From: Laura Gibbons <Laura.Gibbons@arun.gov.uk>
Sent: 05 October 2021 13:21
To: Planning.Responses <Planning.Responses@arun.gov.uk>
Cc: Maria Tomalova <Maria.Tomalova@arun.gov.uk>
Subject: RE: Planning Consultation on: Y/139/21/DOC

Thank you for consulting us, we have the following comments regarding conditions 5 and 6

Application No: **Y/139/21/DOC**

Registered: 21st September 2021
Site Address: Pollards Nursery Lake Lane Barnham PO22 0AD
Description of Works: Approval of details reserved by condition imposed under Y/151/20/PL relating to conditions 5-surface water drainage & 6-discharge flows to watercourses.

SEASONAL WORKERS ACCOMODATION
FOUL AND STORM DRAINAGE

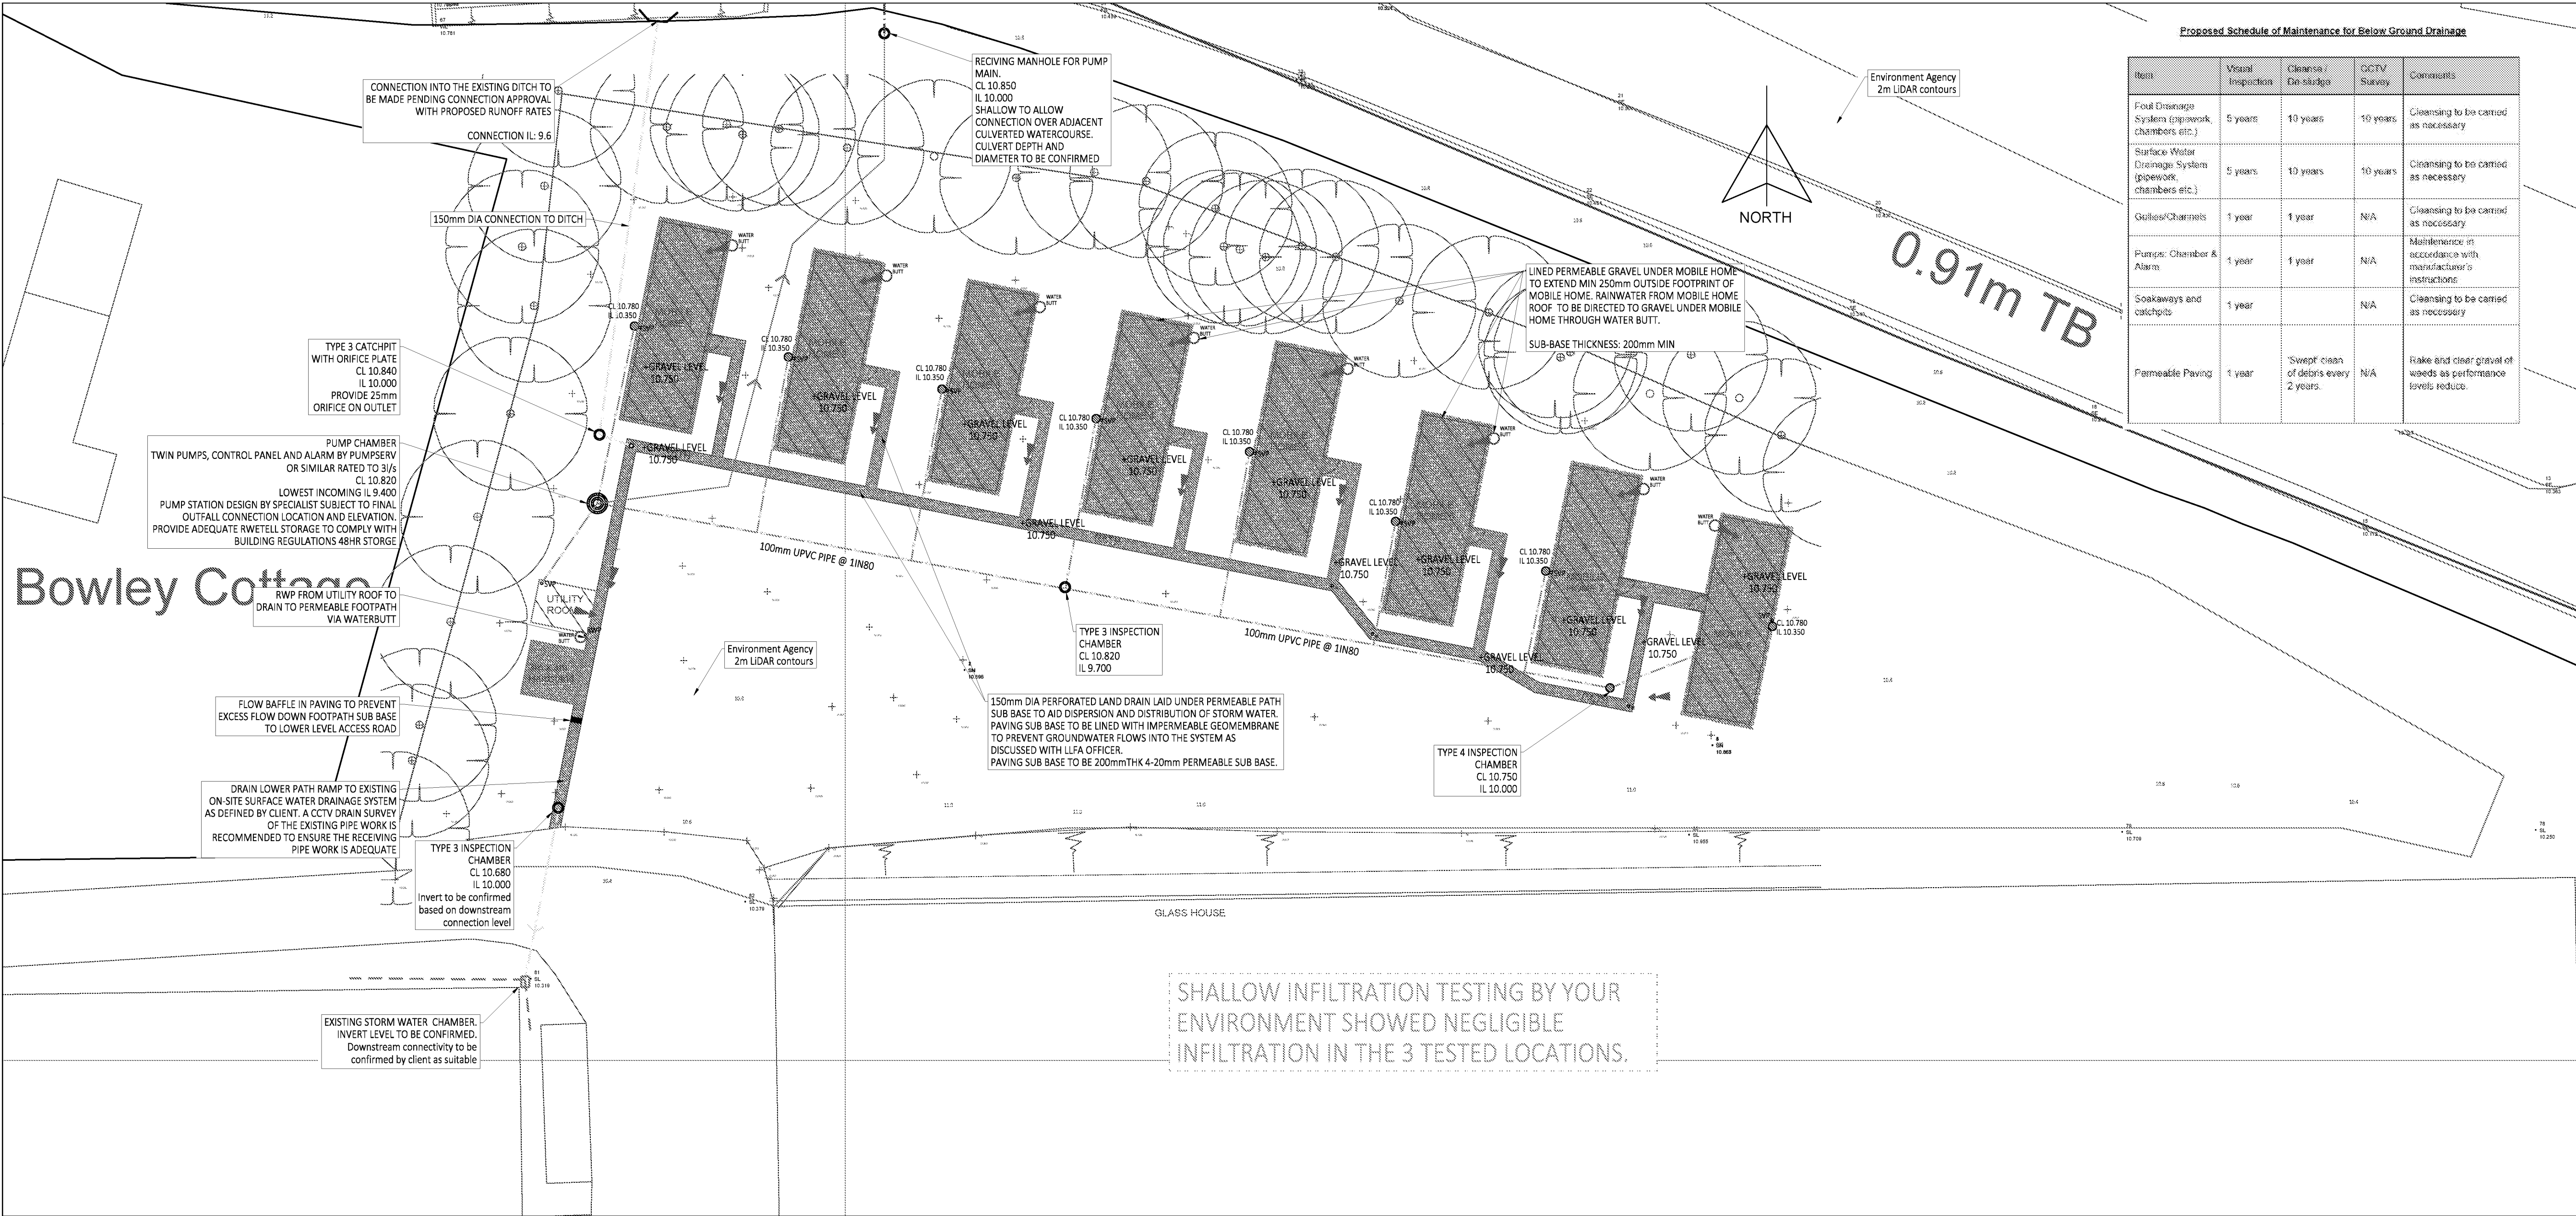
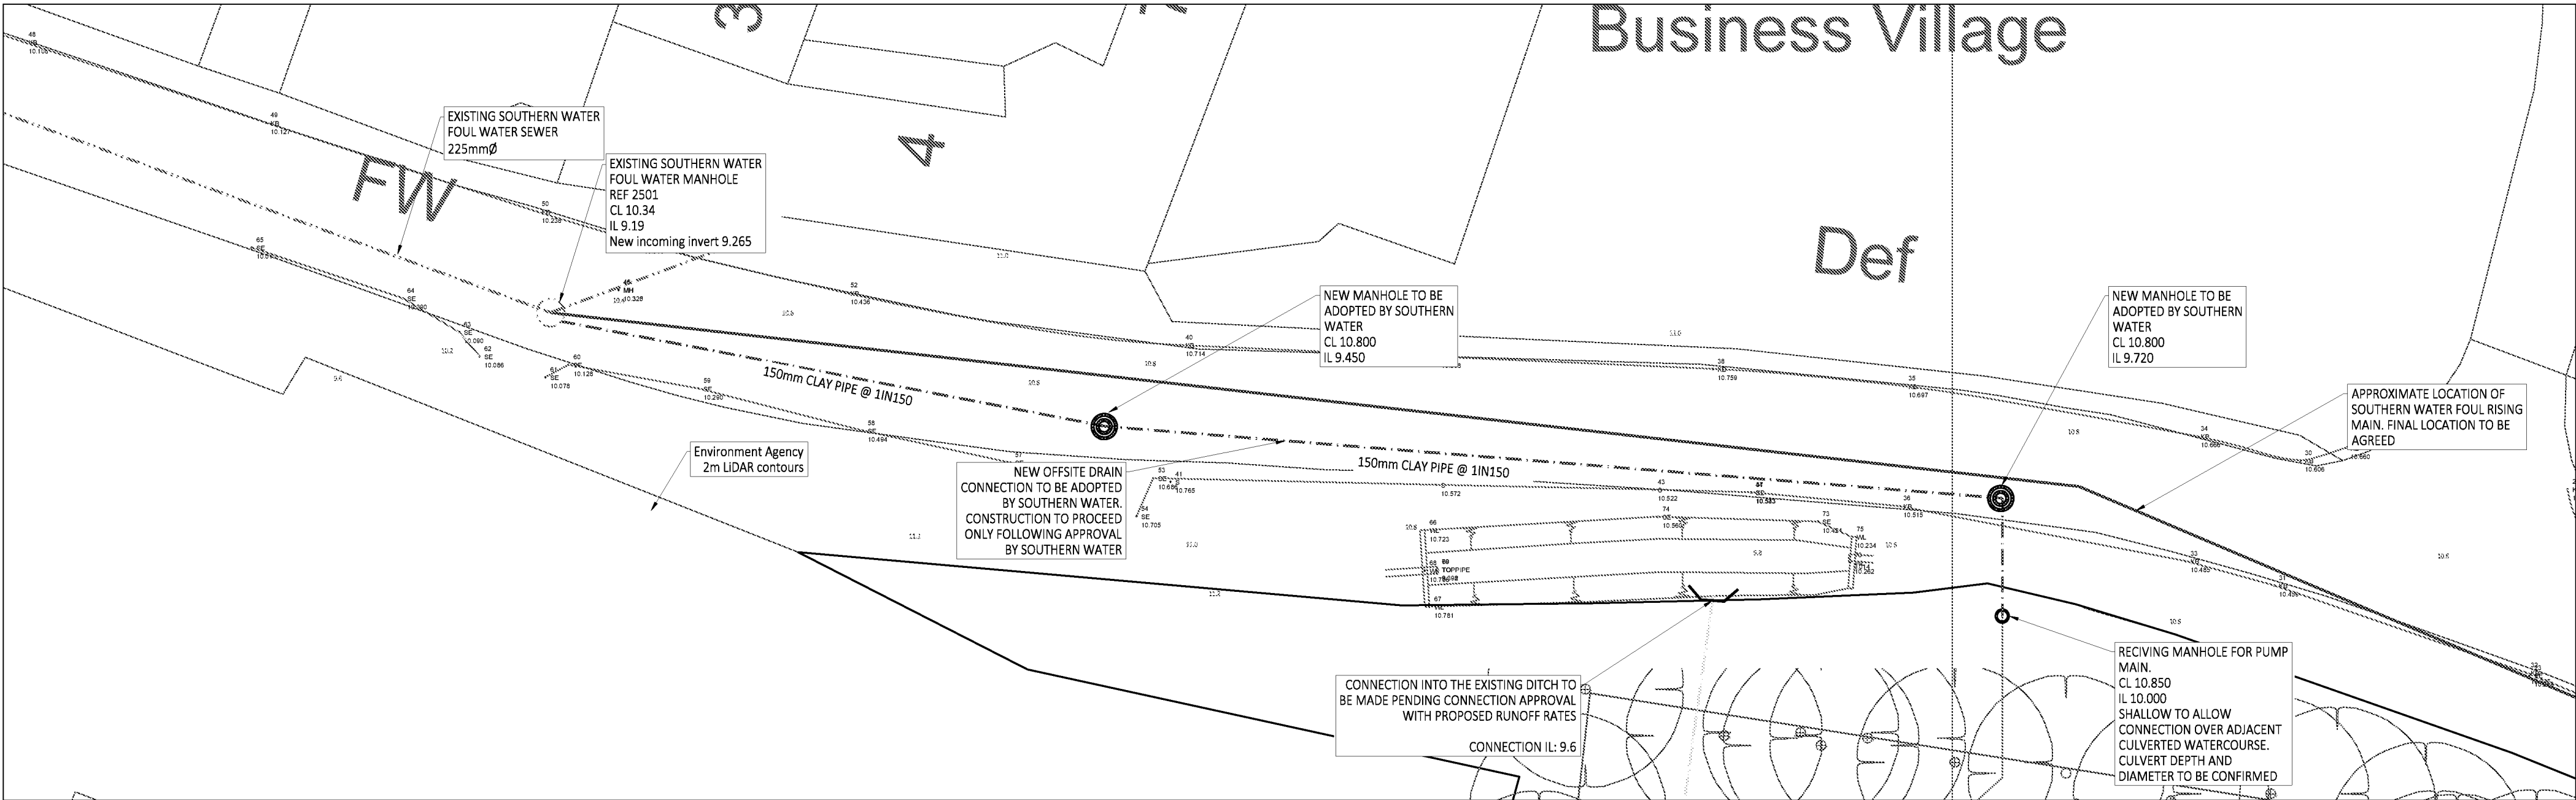
1. It appears that it is proposed to convey surface water through a granular sub-base. This is acceptable in principle, however a fall must be provided on the granular sub-base to promote conveyance. This fall should be reflected in calculations.
2. A surcharged outfall should be modelled in calculations. With surcharged water levels equivalent to top of bank of watercourse.
3. A 25mm orifice is proposed to control discharge rate from the site, this is quite small and could be prone to blockage. We query whether a hydrobrake would achieve a similar flow restriction with a larger aperture?
4. All surface water pipes must be labelled with diameter and fall.

5. The true bed level at the point of connection to the watercourse must be provided, along with soft bed level.
6. Concrete bed and surround must be provided to the new pipe where it passes through the trees.
7. Site specific construction details of the flow control device and outfall must be provided.
